DRB Application No.: 03-00292 (SBP) and 03-00294 (P&F)

Project # 1002326

Project Name: **EAST END ADDITION**

## DEVELOPMENT REVIEW BOARD TRANSPORTATION DEVELOPMENT Standard Comment Sheet

SITE PLAN

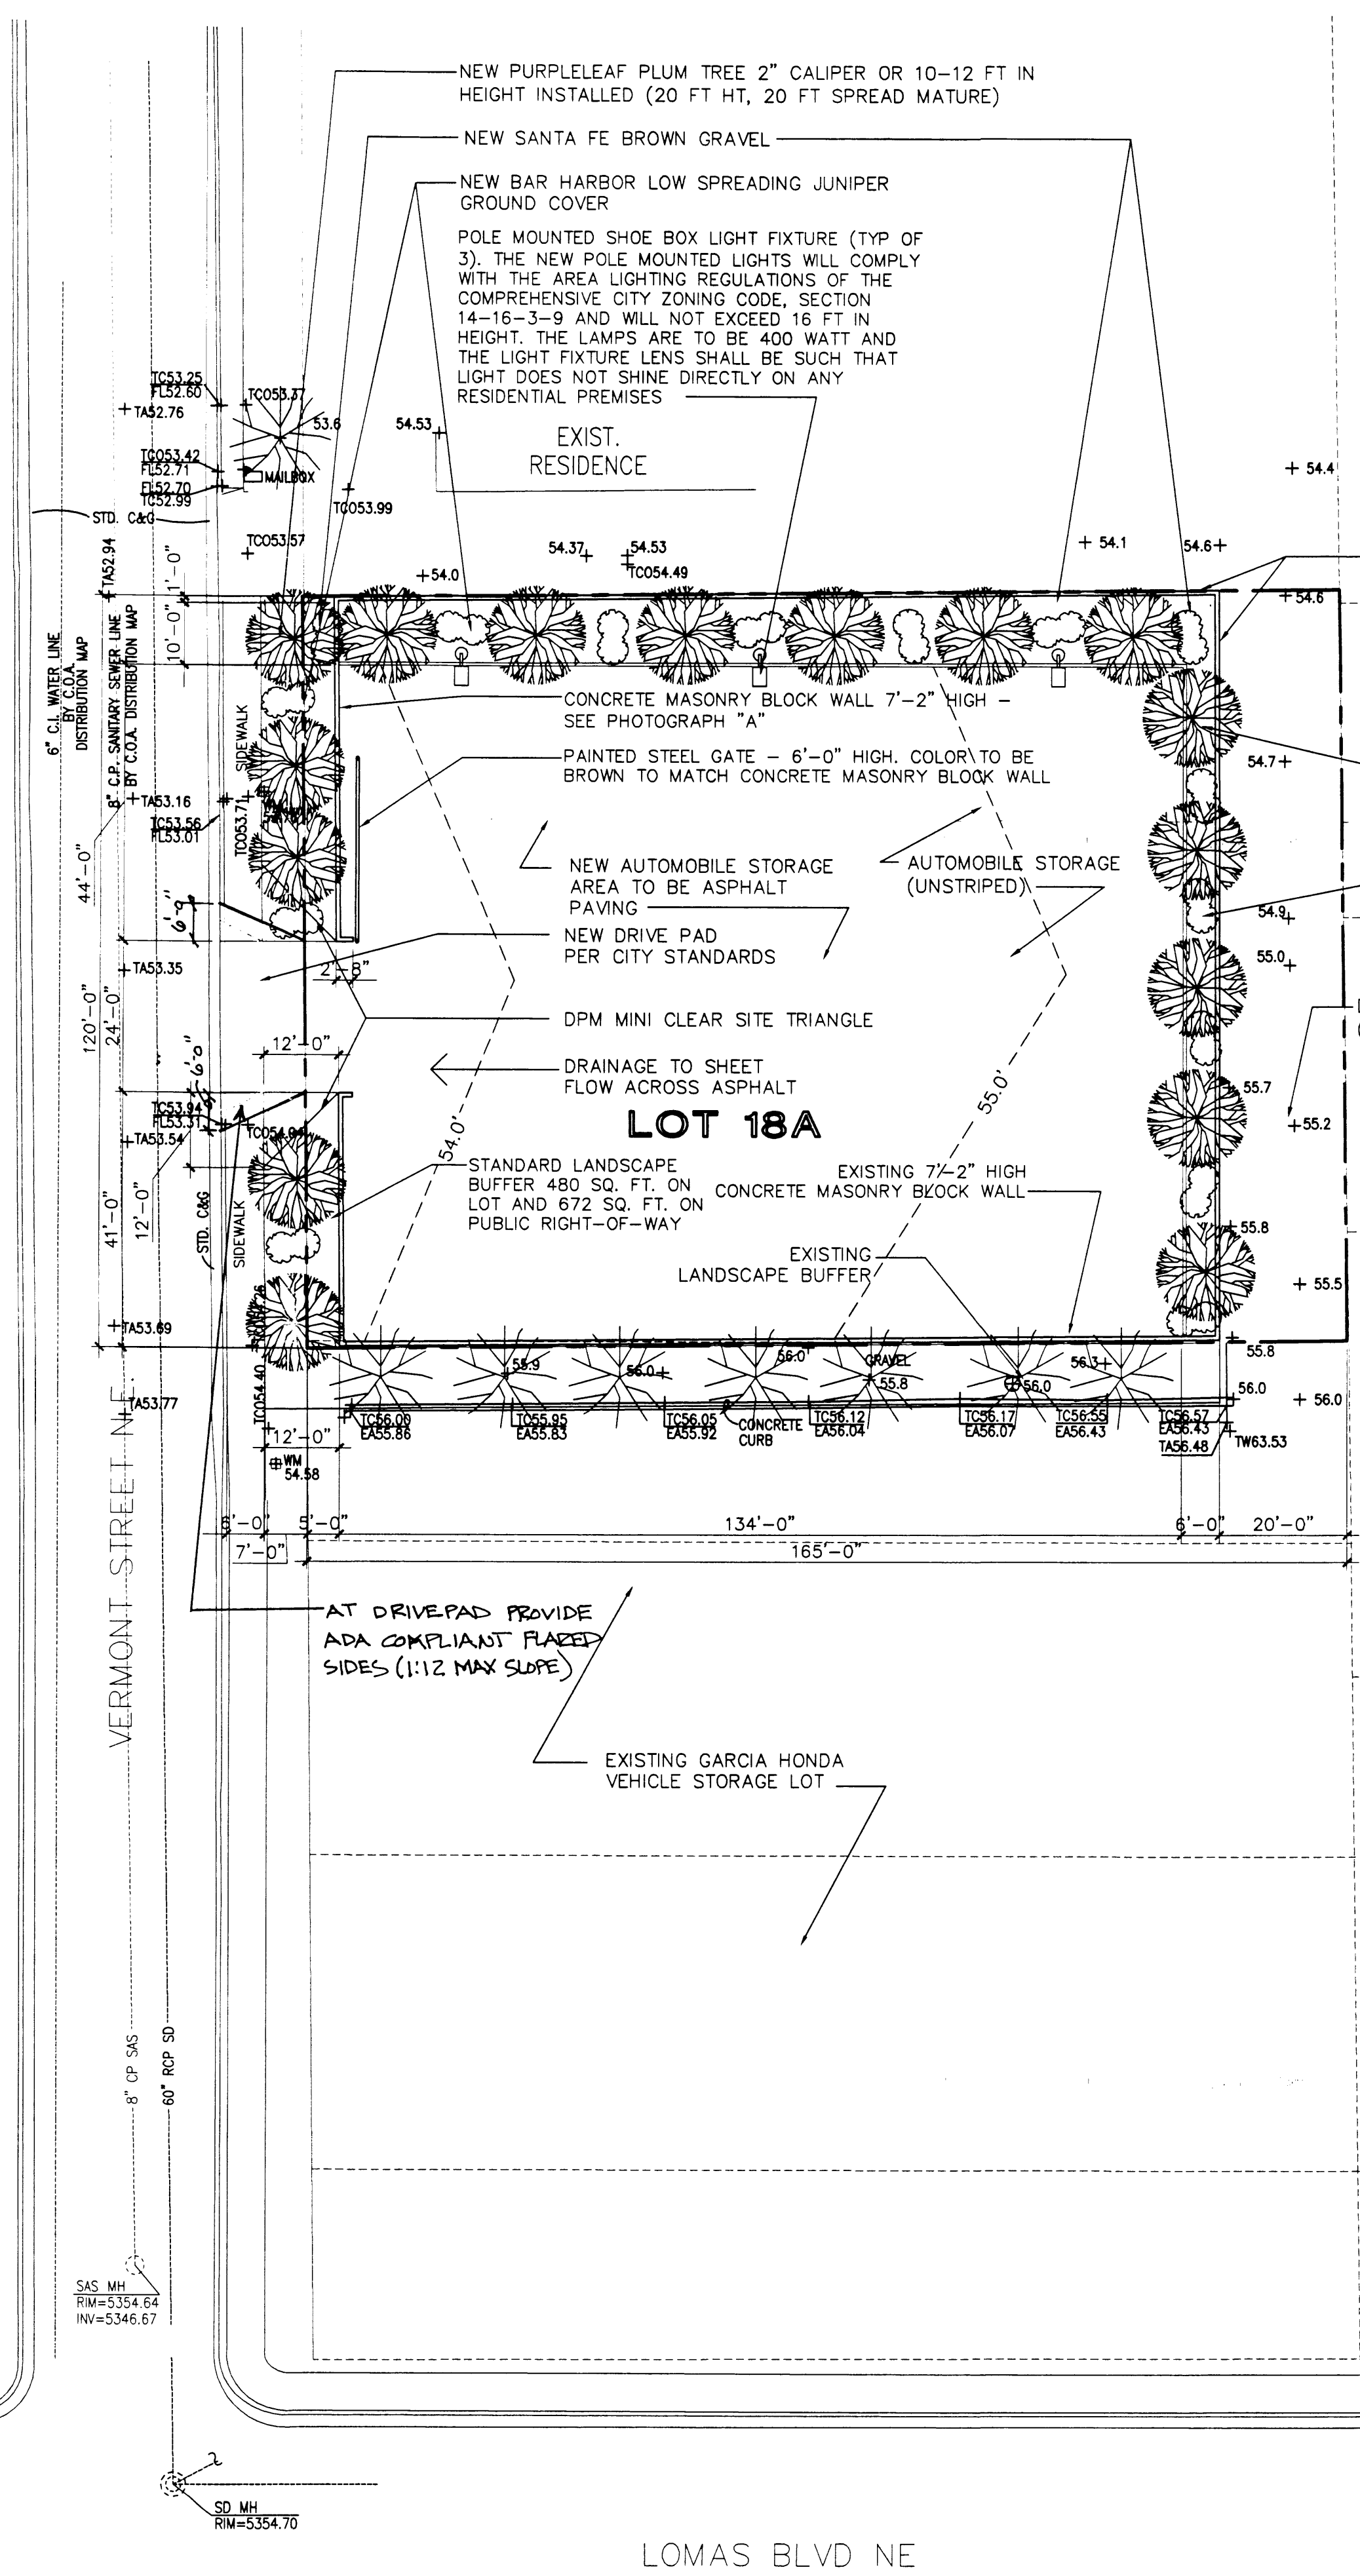
No.	Comment
<input type="checkbox"/>	Show a City Standard ADA drivepad.
